Our ref: Bullecourt Avenue, Milperra- Early Works & Stage 1 (SSD-97092958)

Subject: Request for Additional Information

**Re: Canterbury Bankstown City Council Submission to the Response to
Submissions State Significant Development Application, SSD-97092958 –
(redevelopment of the former WSU Milperra campus)**

STAGE 3B

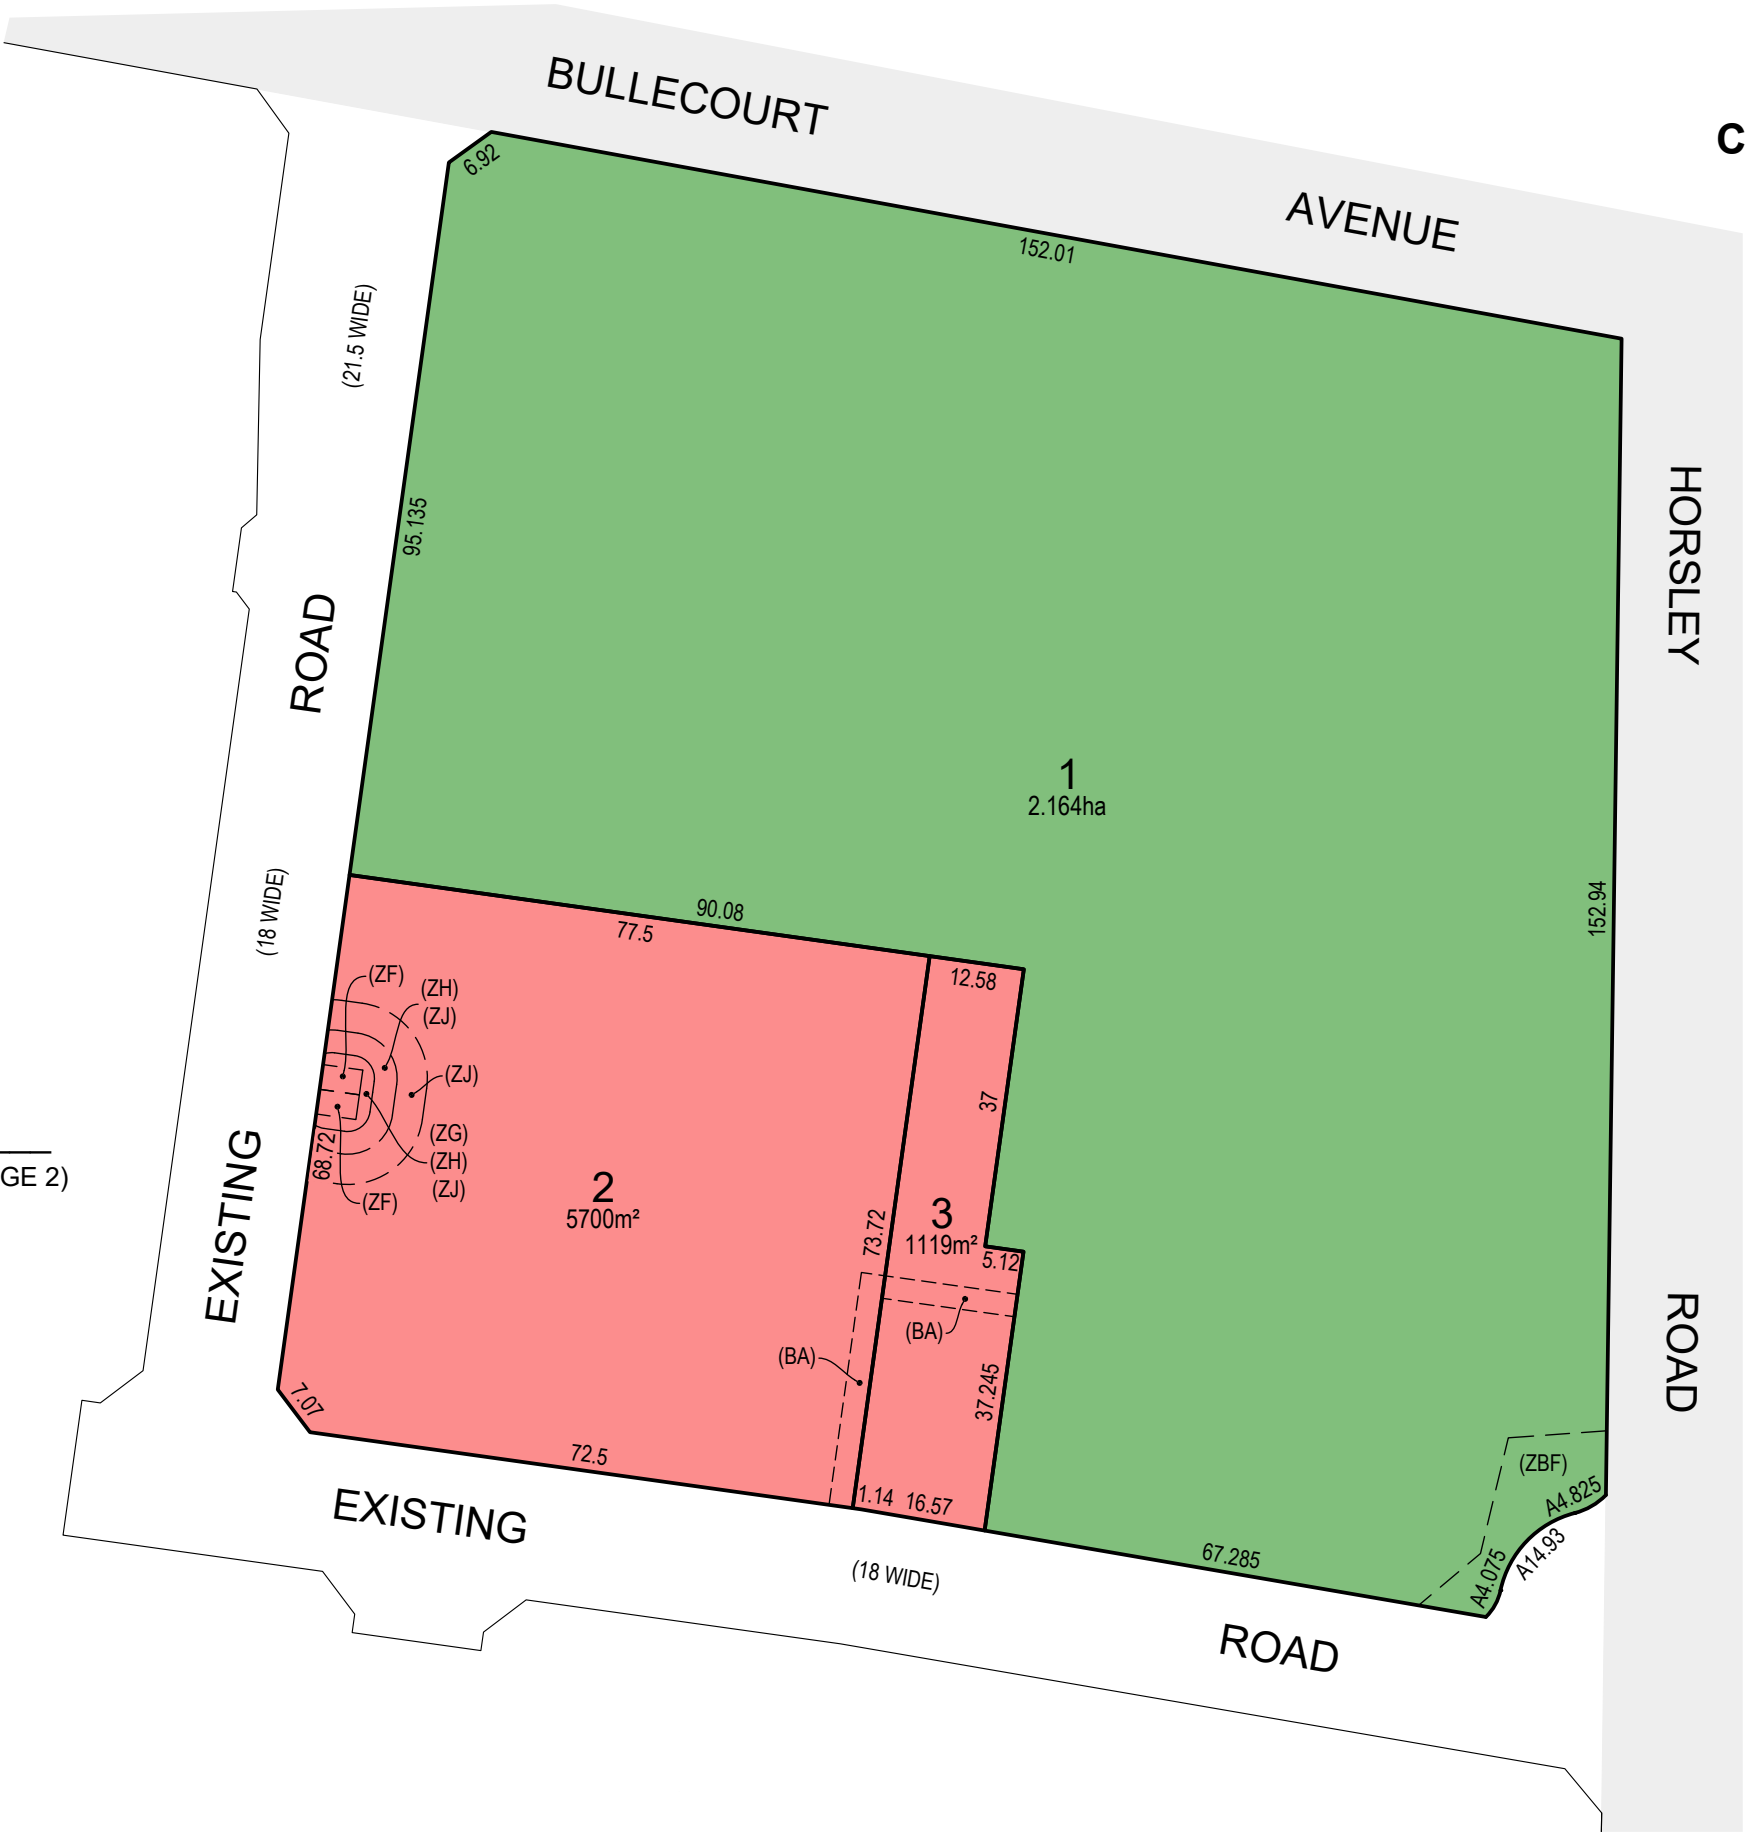
Details of how car parking for the child care centre will be managed and confirmation that access to the required number of spaces will be provided throughout construction and in perpetuity if the car park is located on a separate lot to the child care centre.

1. Council does not accept the proposed community title scheme that locates the parking required for the Child Care Centre on a separate allotment

The proposed subdivision layout results in the separation of the existing childcare building from its car park.

It is unclear why the proposed would separate the lots in the E1 zone and seek to have the Child Care Centre on one lot, and the car parking required to be provided to that same child care centre on another separate lot.

It is noted that this is shown on plans relating to “Stage 3B”, and may not be relevant to the subject SSDA, however as the plan has been provided for review, Council is raising this as a concern.

If the Child Care Centre is to remain operational throughout any construction period, provision needs to be made for car parking to be provided as current car parking provided to the child care centre is proposed to be replaced by a new road.
